**KIRKLEES METROPOLITAN COUNCIL
INVESTMENT & REGENERATION SERVICE**

DELEGATED DECISION TO DETERMINE PLANNING APPLICATIONS

Reference No:	2024/62/93098/E
Site Address:	37, Snelsins Road, Cleckheaton, BD19 3UE
Description:	Erection of single and two storey side extension
Recommending Officer:	Joshua Merriman

HOUSEHOLDER DELEGATED REPORT

Showing:
'As Existing & As Proposed'
Parking Plan

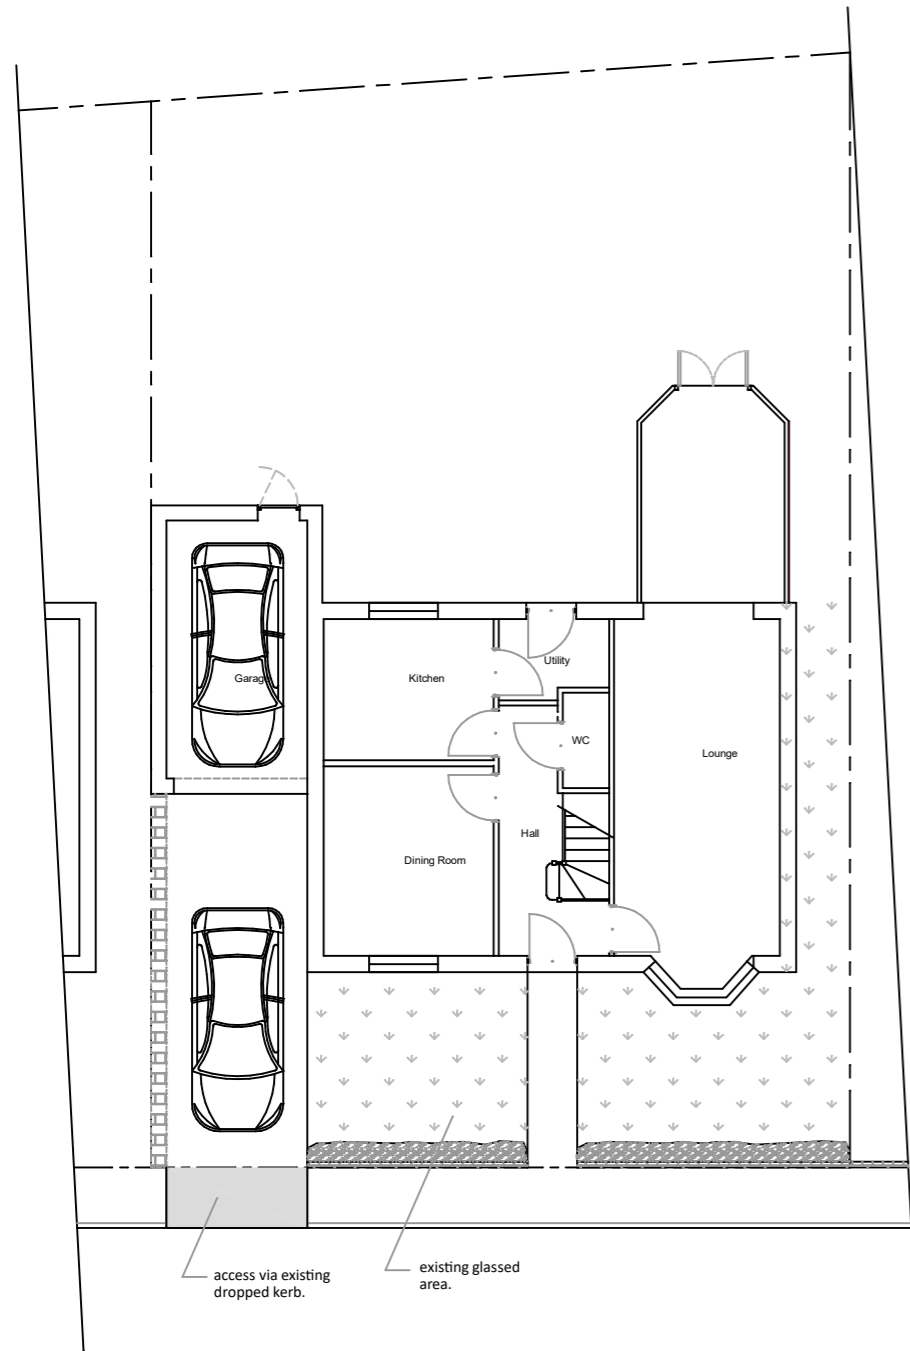
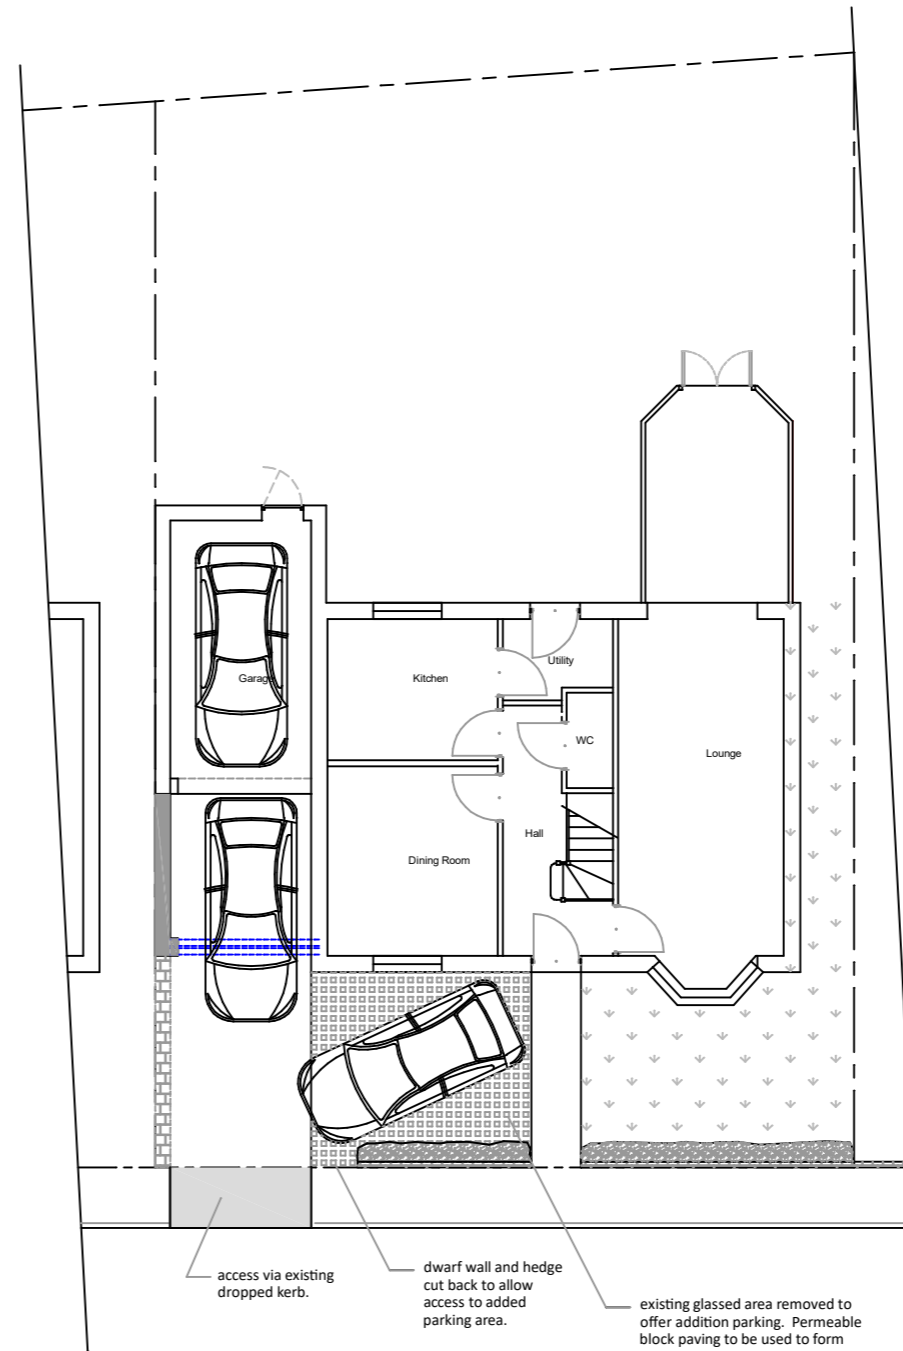
open space – Compliance with Conditions.
Consultations required	Yes	KC Highways – The highways team requested the submission of a parking layout plan for three off-street parking spaces. This was submitted by the applicant and deemed acceptable by the highways team, therefore, there are no objections to this proposal.

Relevant key design principle (KDP) of the SPD, Policy in the Kirklees Local Plan and the NPPF	Further comments	✓ / X / N/A
Impact on highway safety	<ul style="list-style-type: none"> • KDP 15 of the SPD • Policy LP22 Parking (f) of the KLP • Chapter 12 of the NPPF 	As the submitted parking layout plan has identified the ability for three parking spaces on the site, it is considered that the proposal would have no significant impact on highway safety.	✓
Parking provision	<ul style="list-style-type: none"> • KDP 15 of the SPD • Policy LP22 Parking (f) of the KLP • Chapter 12 of the NPPF 	A parking layout plan detailing three off-street spaces was submitted at the request of the highways team, and this has been deemed acceptable by the highways team, therefore, the parking provision is acceptable.	✓
